Our Ref: BR/207/18/HH

**Town & Country Planning Act 1990 (as amended)
Town & country Planning (Development Management Procedure) (England) Order 2015
Application for Planning Permission for Works or Extension to a Dwelling**

Development Single storey side extension
Location 84 Brooks Lane Bognor Regis

ELEVATIONS. As Prop^d

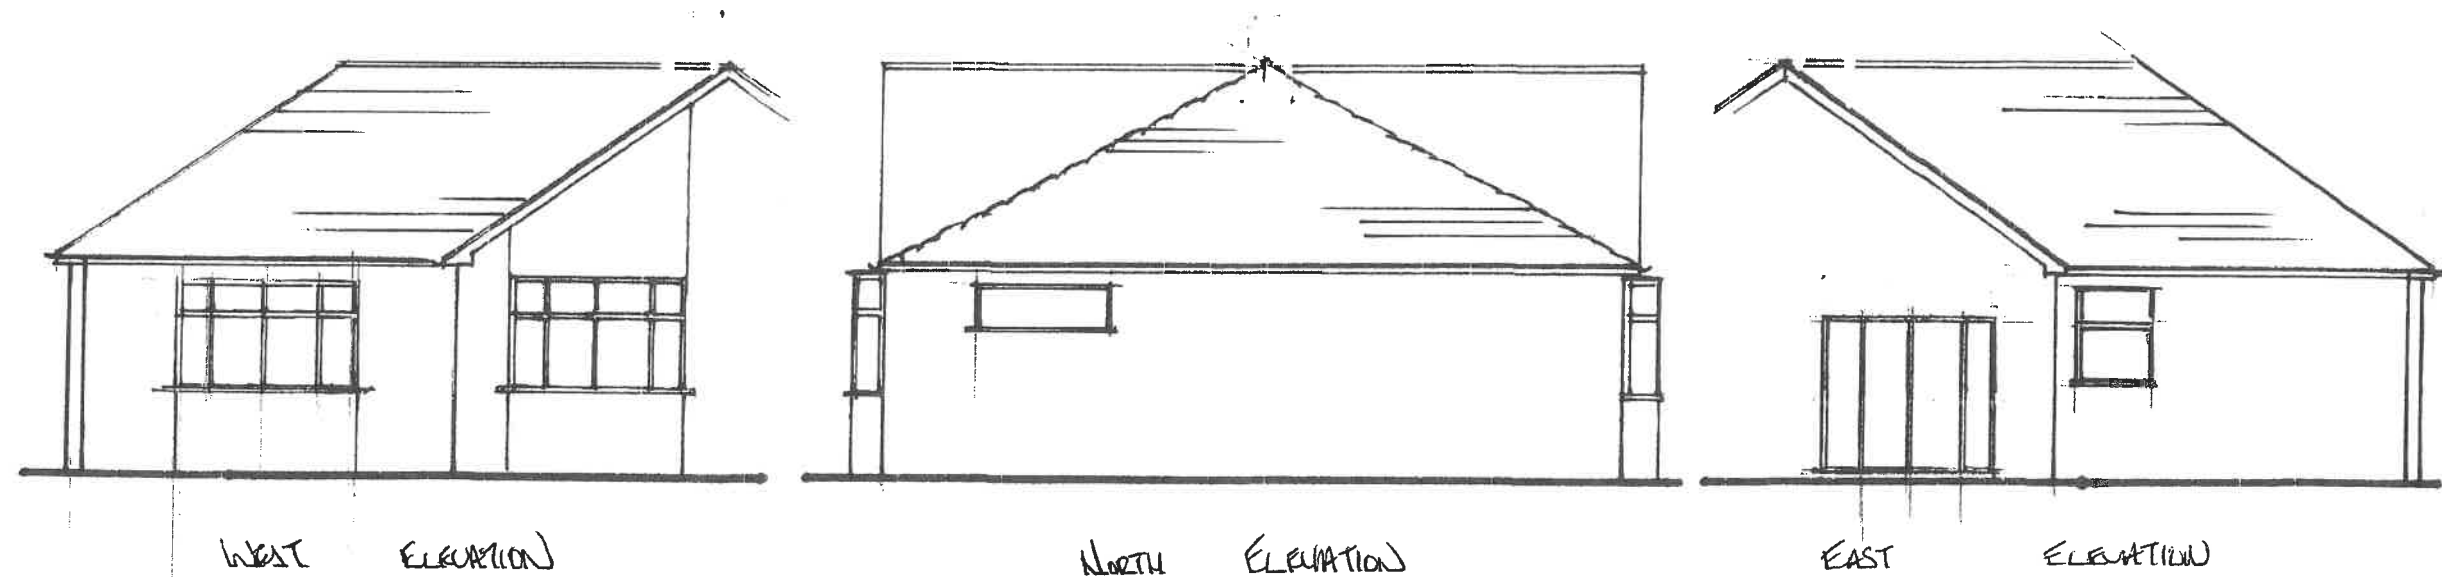
Please label the existing and proposed elevations as north, south, east or west as appropriate.
